MEMORANDUM

TO: Nell Donaldson, Planner
FROM: David Senus, P.E.
DATE: May 11, 2015
RE: 72 Bishop Street Efficiencies, Final Level III Site Plan Application

Woodard & Curran has reviewed the Final Level III Site Plan Application for the proposed efficiencies located at 72 Bishop Street in Portland, Maine. The project involves the construction of 30 housing units with 12 parking spaces and associated site improvements.

Title:  
 GRADING, DRAINAGE &  
 UTILITIES PLAN

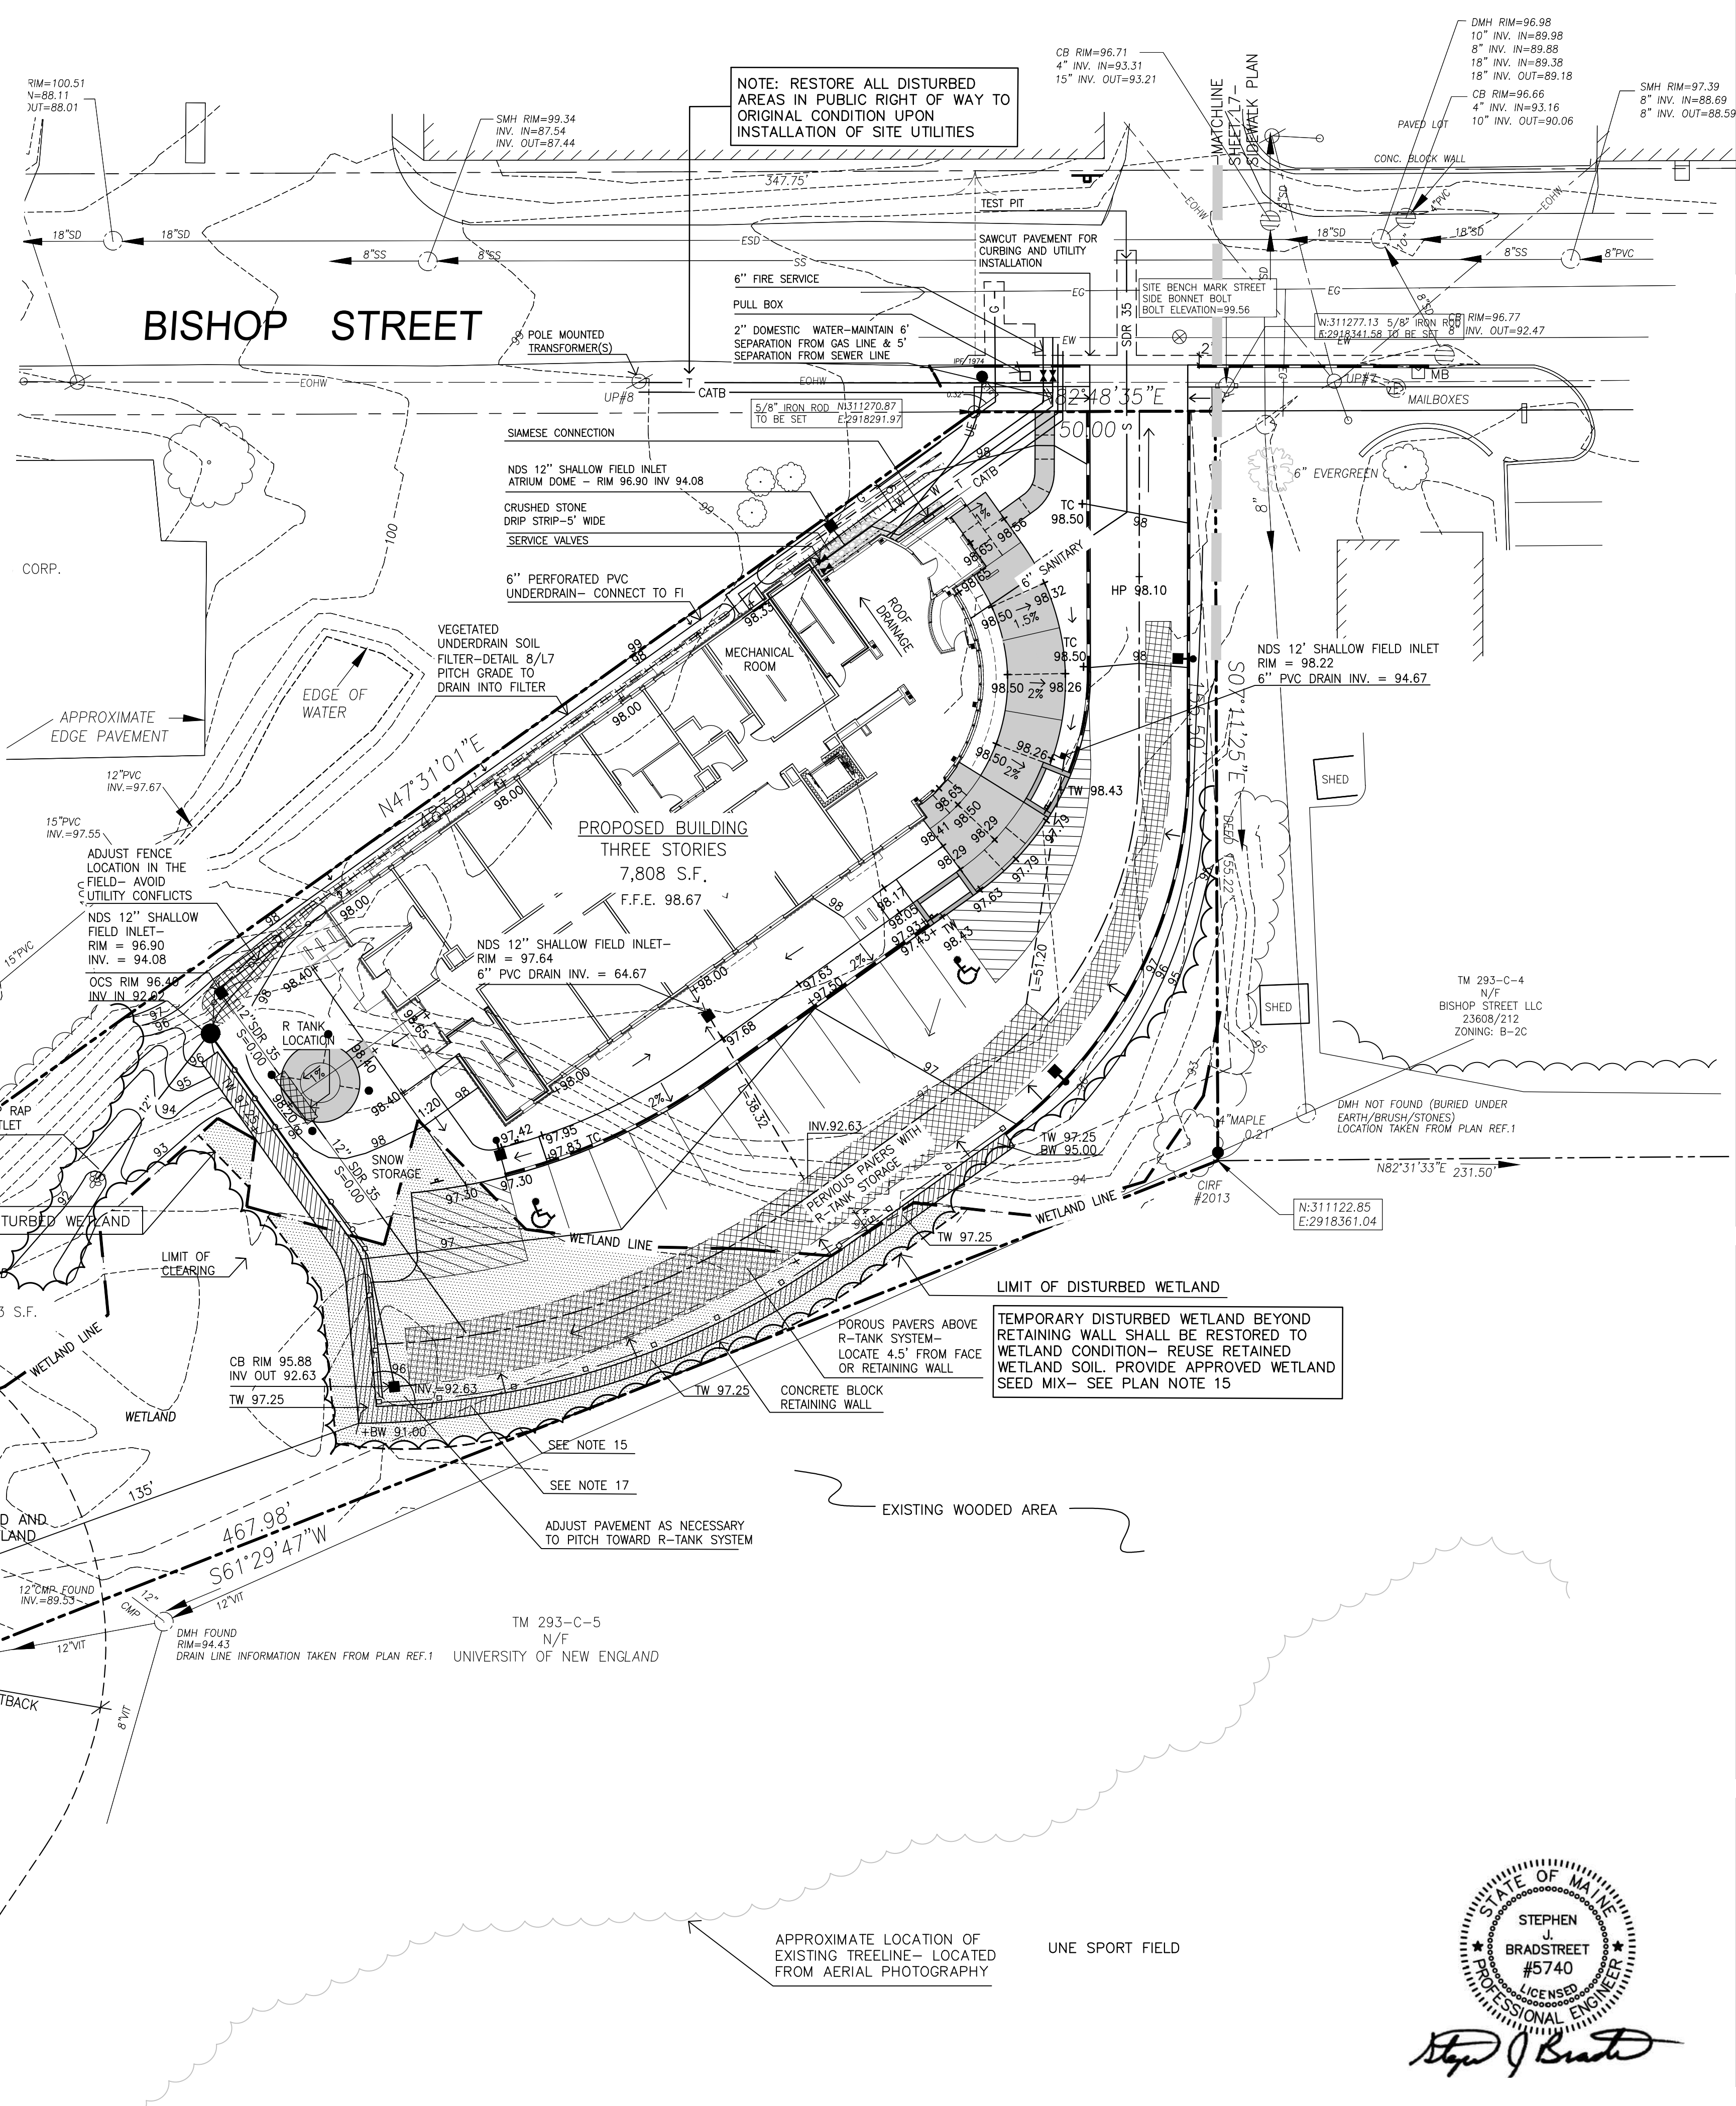
- i) It is unclear from the plans how the stormwater management system will be interconnected; it does not appear that the equalizing pipe connecting the two R-Tank systems is shown, and the method of discharging from the outlet control structure is unclear. It is also unclear how the roof drainage crushed stone drip strip will connect to the R-Tank system. Proposed storm drain piping should be clearly labeled with size, material, slopes, and invert elevations and more detail should be provided on the interconnections between the various stormwater management systems on the site.

- 9) It appears that the Applicant is proposing to daylight the outlet of the Outlet Control Structure. Outlet protection measures should be provided at the discharge location. The Applicant should also clarify whether the proposed J-drain will daylight adjacent to the Outlet Control Structure, or if it is intended to connect to the Outlet Control Structure. The plans should be clarified in this area.
